SOLACE APARTMENTS FILING NO. 2

A PORTION OF SECTION 7, TOWNSHIP 14 SOUTH, RANGE 65 SEST OF THE P.M.
EL PASO COUNTY, COLORADO
CONSTRUCTION DOCUMENTS

CIMARRON HILLS - PHASE 2
CONSTRUCTION DOCUMENTS
COVER SHEET

SHEET
C-001

SHEET
C-002

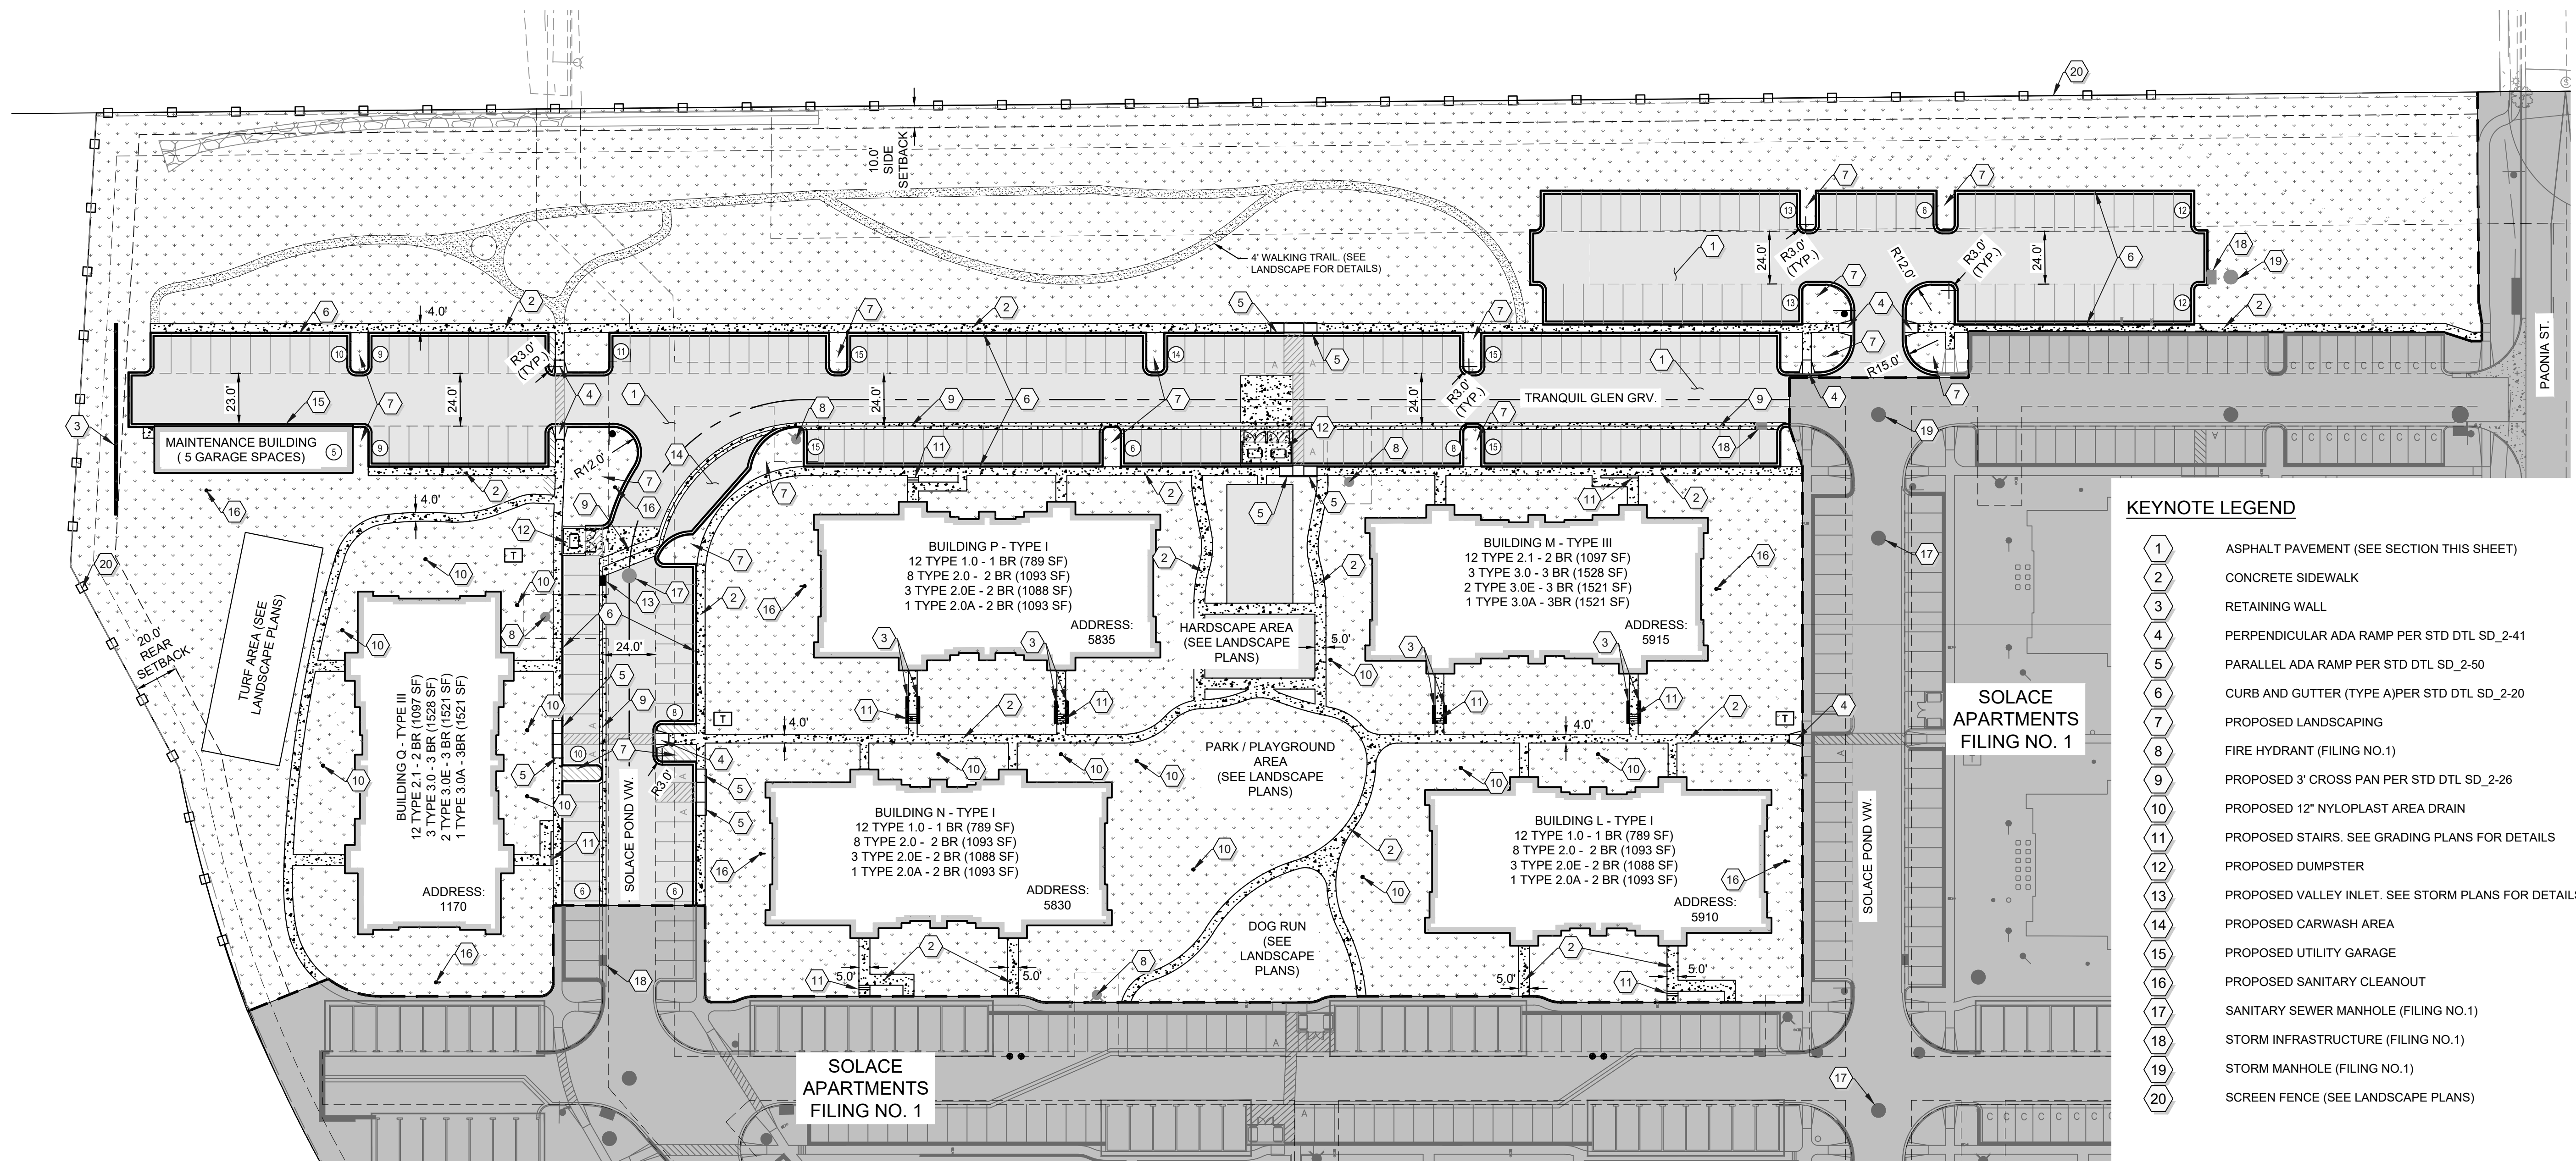
Revise. The soils report that was submitted was prepared by CTL Thompson.
